Application number: 2025/92242	
What is the application for?:	Reserved matters application (including consideration of appearance, scale and l
Address of the site or building:	Land off, Hermitage Park, Lepton, Huddersfield, HD8 0JU
Postcode:	WF2 7UA

Type of comment: An objection	
Do you wish your comments to be published on the website anonymously?	No
The submitted proposals do not consider the ancient woodland or public safety. The NPPF states "Development resulting in the loss or deterioration of irreplaceable habitats (such as ancient woodland and ancient or veteran trees) should be refused, unless there are wholly exceptional reasons and a suitable compensation strategy exists" Natural England and Forestry Commission Standing Advice suggests a minimum 15m buffer zone this is to avoid root damage only, other impacts extend beyond this distance resulting in a larger buffer zone requirement. They state buffer zones "should consist of semi-natural habitats such as woodland, a mix of scrub, grassland, heathland and wetland planting" The Woodland Trust states "Many problems stem from unmanaged access • Frequency of fly-tipping into woodland • Dumping of garden waste into woodland le

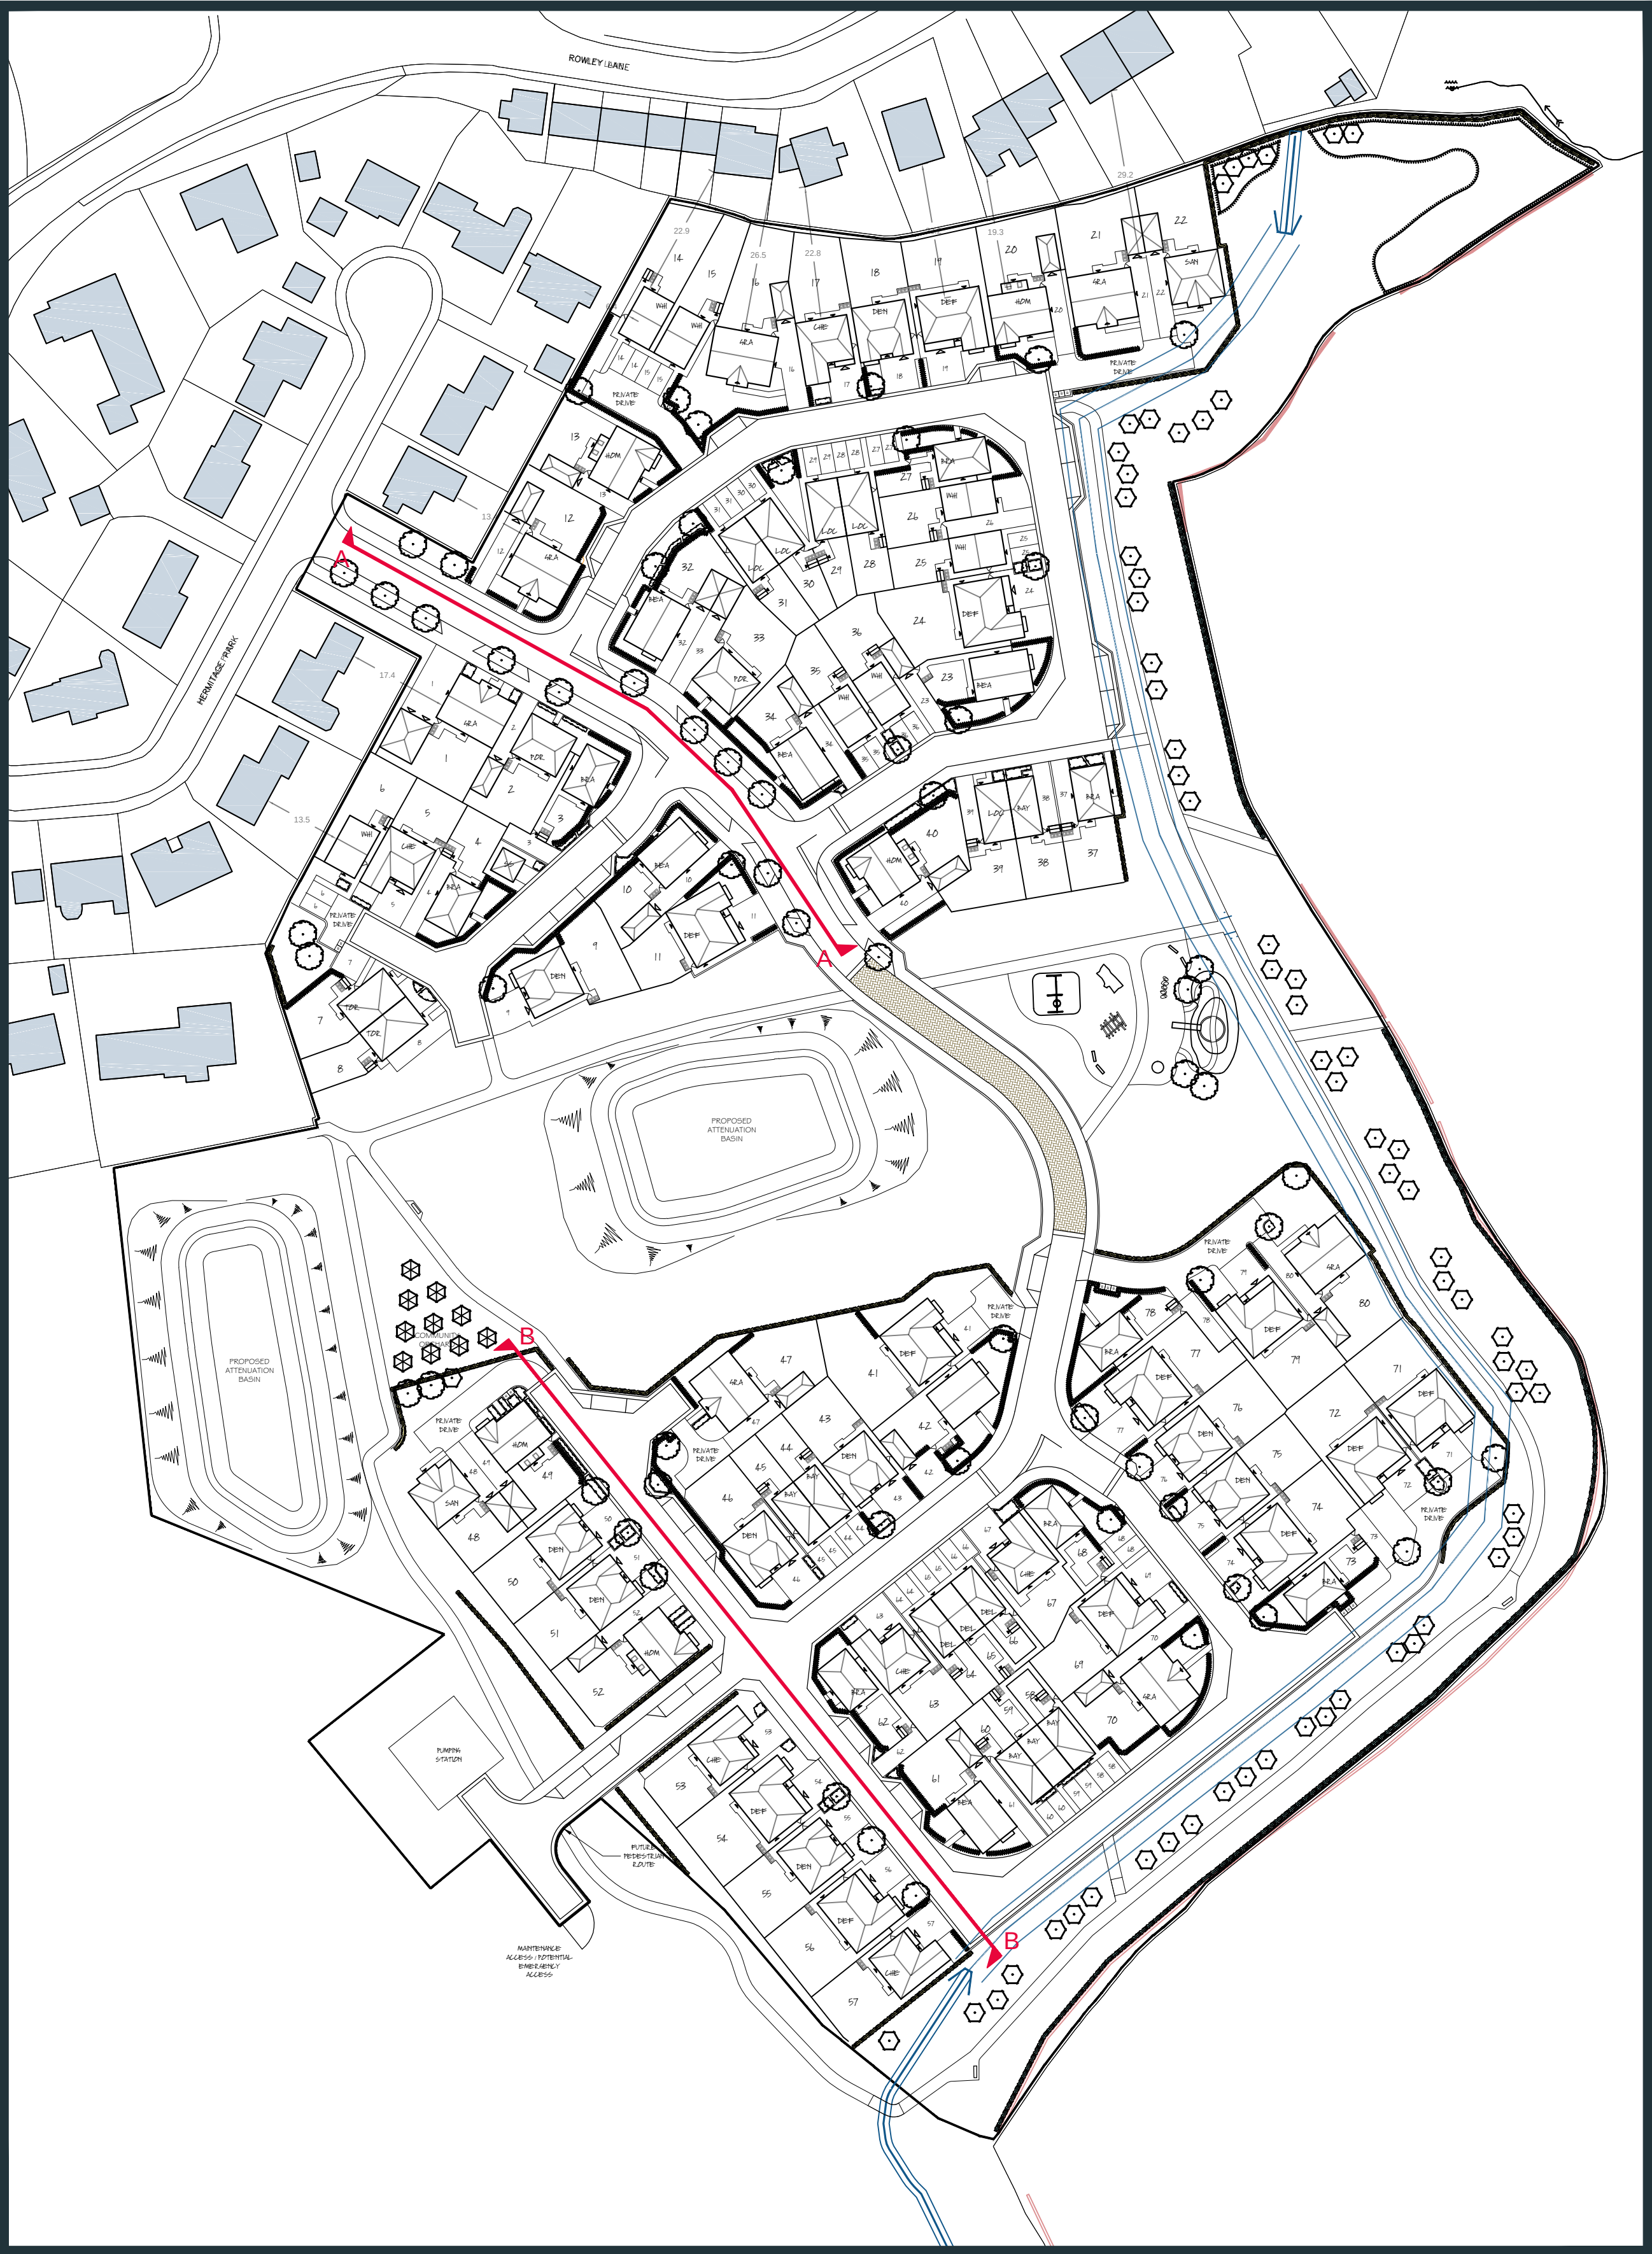
Falling branches and trees are common yet the proposals show a buffer that is vastly insufficient and promotes access.

It is a strict requirement by other LPAs that fenced off planted buffers 50-100m wide be incorporated and Kirklees Council must enforce this to meet their environmental and public safety obligations.
